From: Chantelle Bashford [REDACTED]
Sent: 08 March 2022 10:46
To: Planning.Responses <Planning.Responses@arun.gov.uk>
Subject: RE: Planning Consultation on: BR/29/22/PL

Please see Private Sector Housing comments below. These comments are in relation to Houses in Multiple Occupation (HMOs) and have regard to the Housing Act 2004, The Licensing and Management of Houses in Multiple Occupation and Other Houses (Miscellaneous Provisions) (England) Regulations 2006, Arun District Council's HMO Standards, Housing Health and Safety Rating System (England) Regulations 2005 and LACORS national fire safety guidance.

Application No:	BR/29/22/PL
Registered:	9th February 2022
Site Address:	Selwood Lodge 93 Victoria Drive Bognor Regis PO21 2DZ
Grid Reference:	493128 99655
Description of Works:	Change of use from C1 Guest House to a 16 bed House in Multiple Occupation (Sui Generis) including first floor extension, demolition of existing detached garage and external alterations.

PROPOSED GROUND FLOOR PLAN
1:50

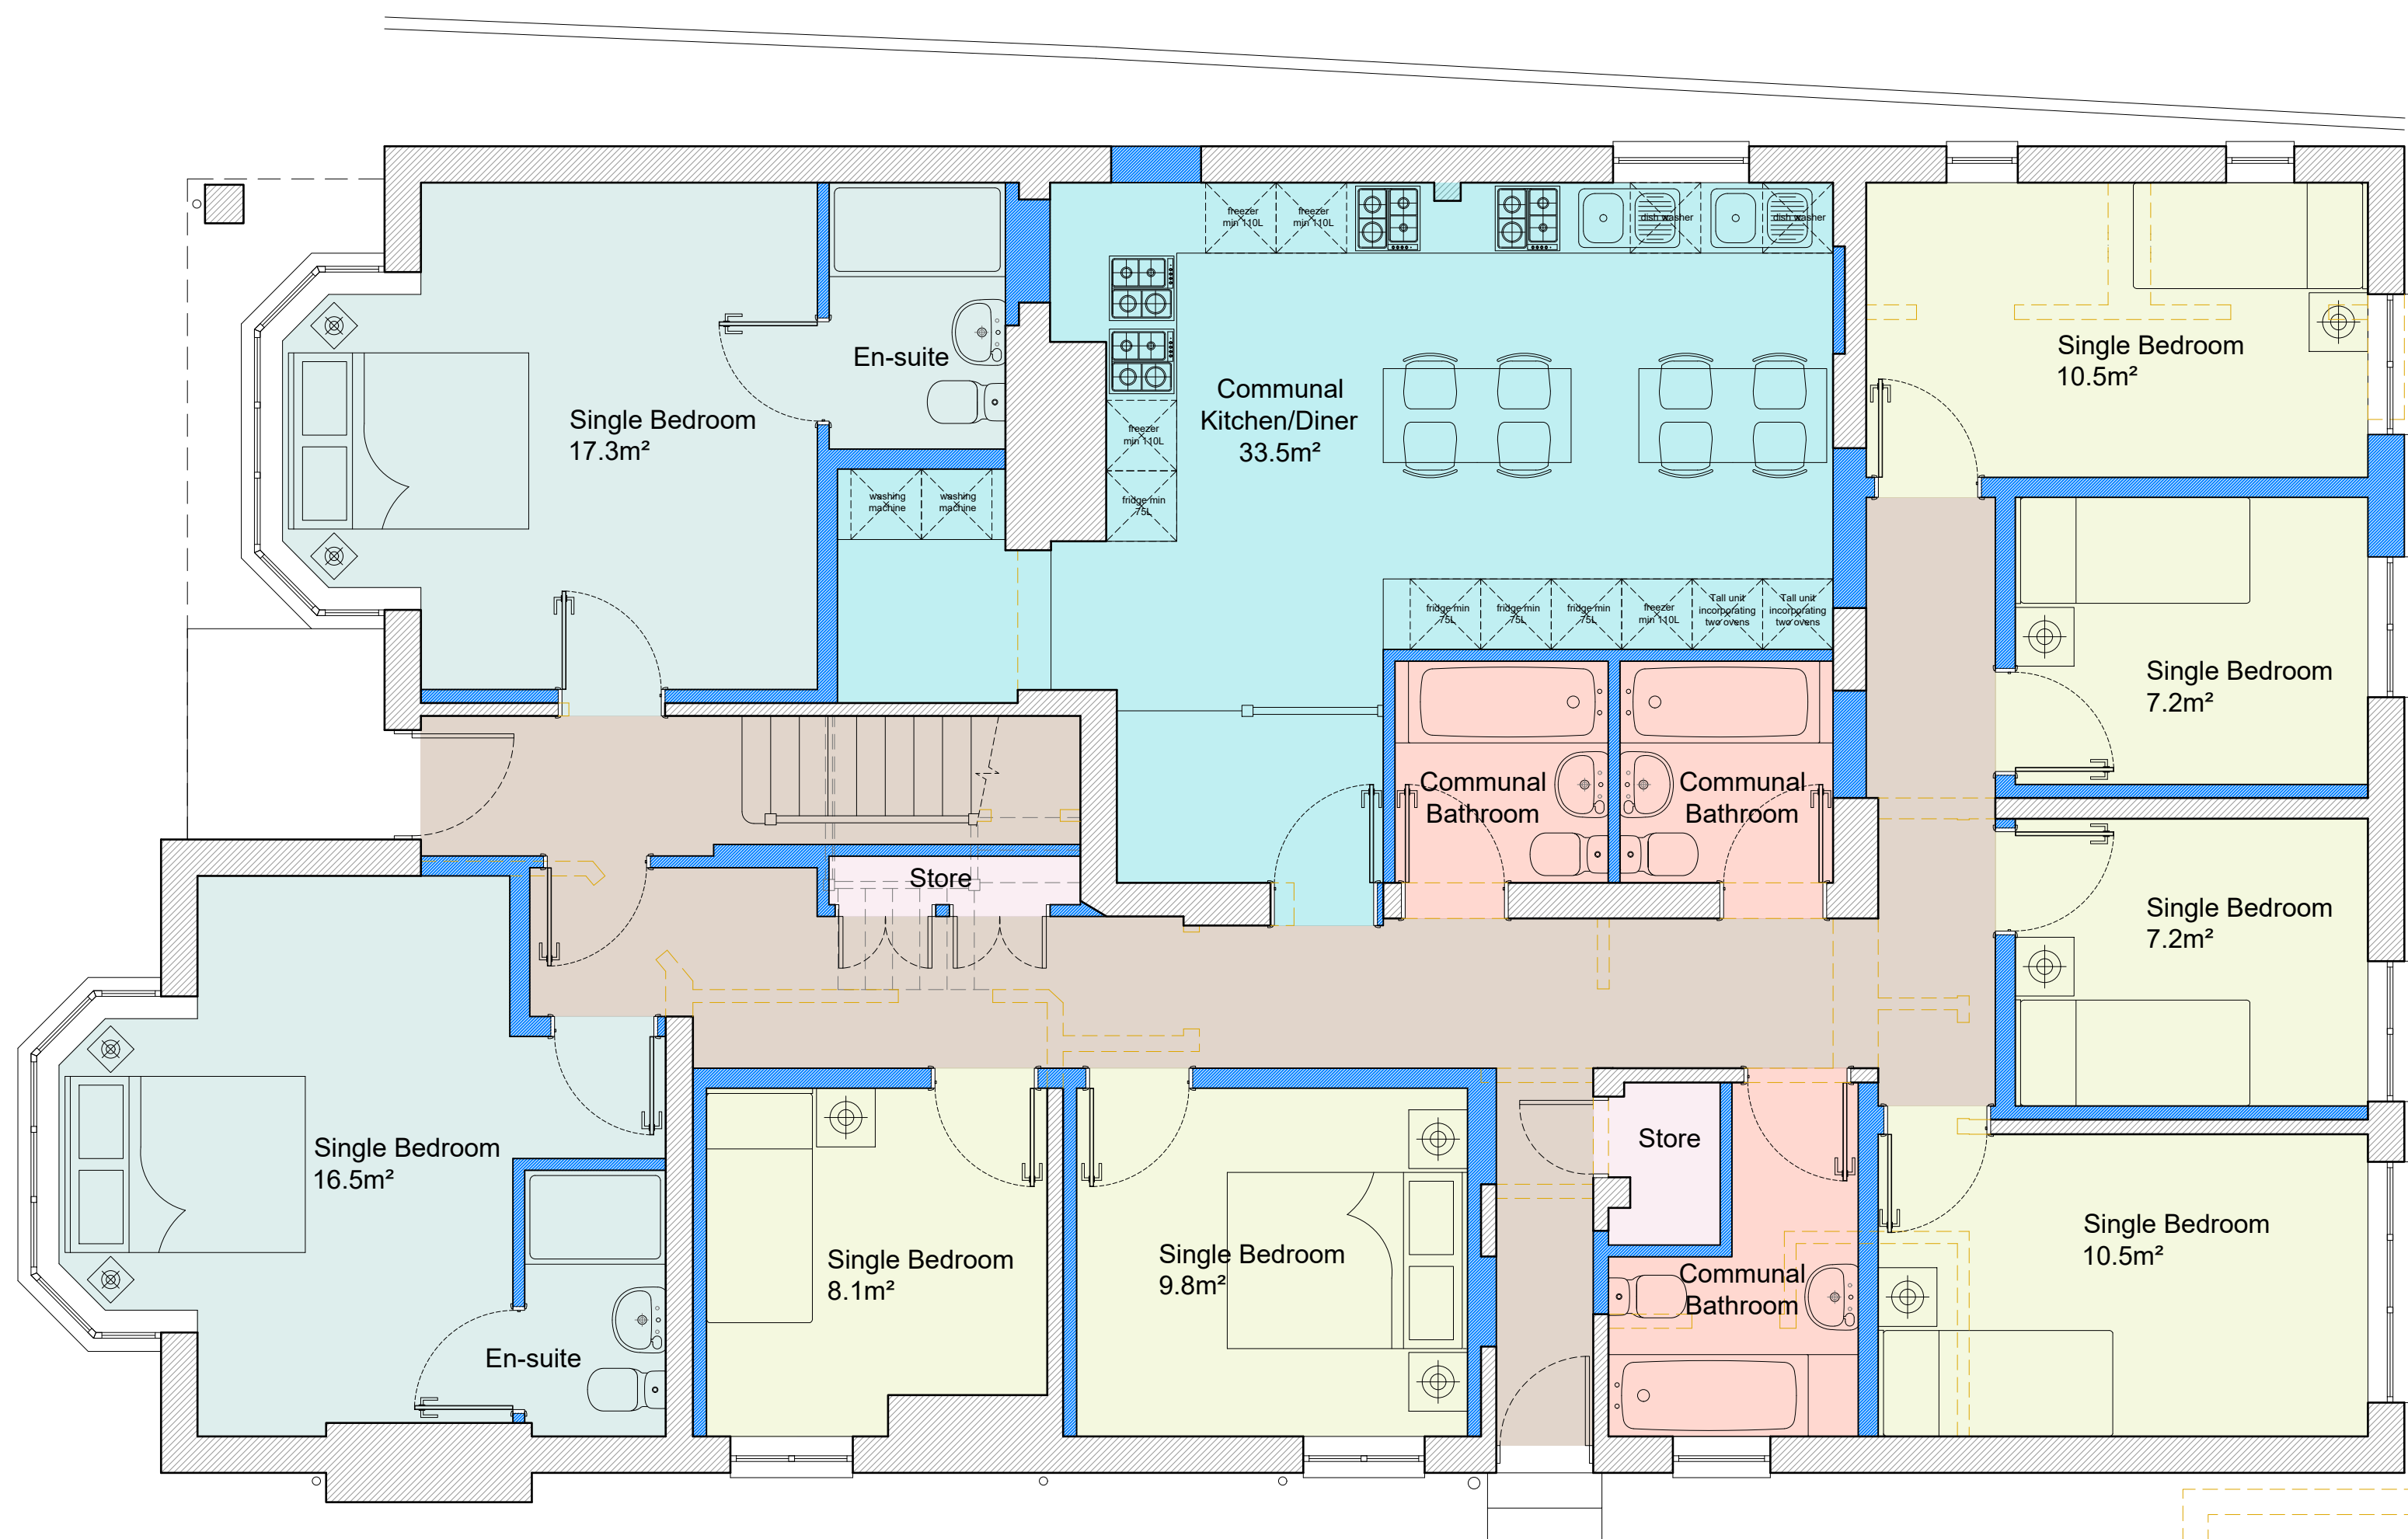
- The size of the kitchen is sufficient for the proposed number of occupants, however the proposed layout suggests there may be insufficient space to provide the required amenities. For example, for 16 occupants 3x sink and drainer units are required plus a dishwasher (or a fourth sink and drainer unit) and minimum 500mm (L) x 600mm (D) worktop space should be provided per user (equating to approx. 8 meters total in this instance)

- The proposed ensuite bathrooms, in particular to the first floor, do not appear to be of an adequate size or layout. Bathrooms must be of an appropriate size to provide adequate changing and drying space for the user. From the proposed plans, it seems likely the users would collide with either the walls and/or the amenities within the bathrooms. The Licensing and Management of Houses in Multiple Occupation and Other Houses (Miscellaneous Provisions) (England) Regulations 2006 specifies that all bathrooms must be of an adequate size and layout; this is also echoed within Arun's HMO Standards document. In addition, this could be identified as a hazard under the Housing Health and Safety Rating System (HHSRS). Consideration should be given to reconfiguring the ensuite bathrooms
